Application for a Non-Material Amendment Following a Grant of Planning Permission

DC/21/05632 Erection of single storey side extension to form ensuite and extend existing bedroom

DC/21/05632 planning permission granted. My client wishes to replace the external brickwork skin with blockwork finished with horizontal cladding using 'Hardiplank, grey slate'

Scale	Date	Drawn No	Revision
1:50, 1:100	Sept 2021	75.01.21	B
A. Section and drainage added 10.2.22			
B. External Finish changed May 2023

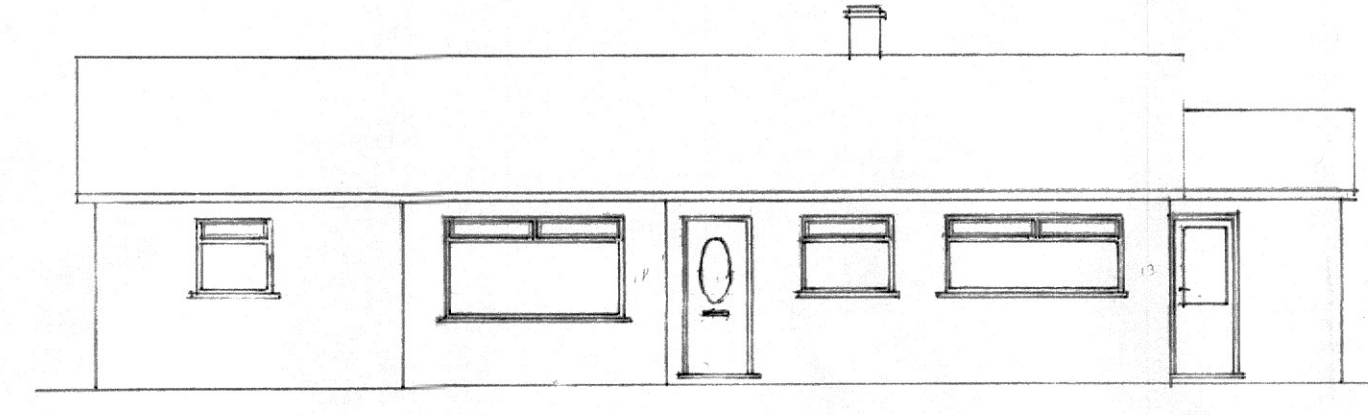
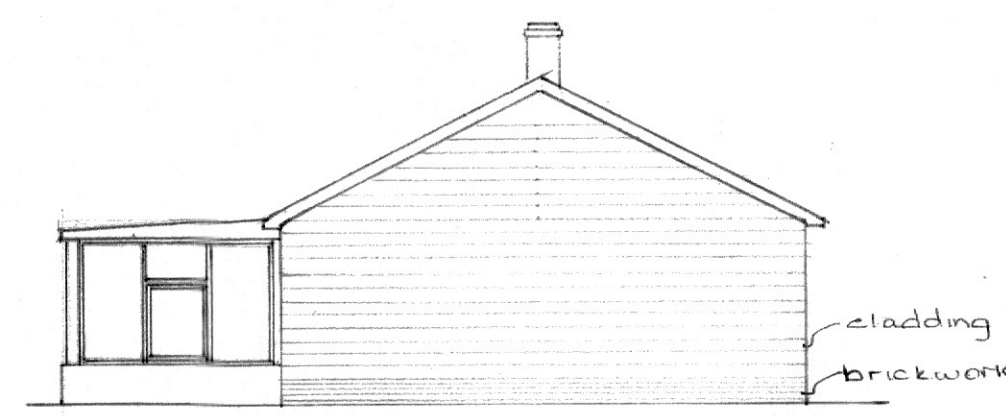
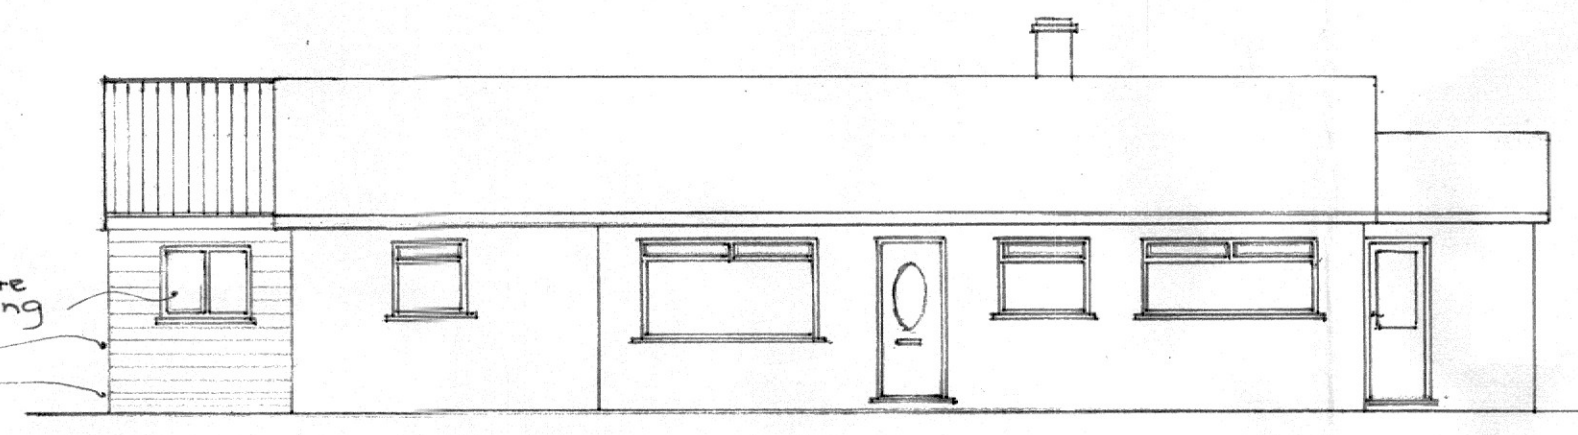
My client wishes to break up the elevation to reduce it's block appearance. The use of horizontal cladding will achieve this and provide interest to the street elevation.
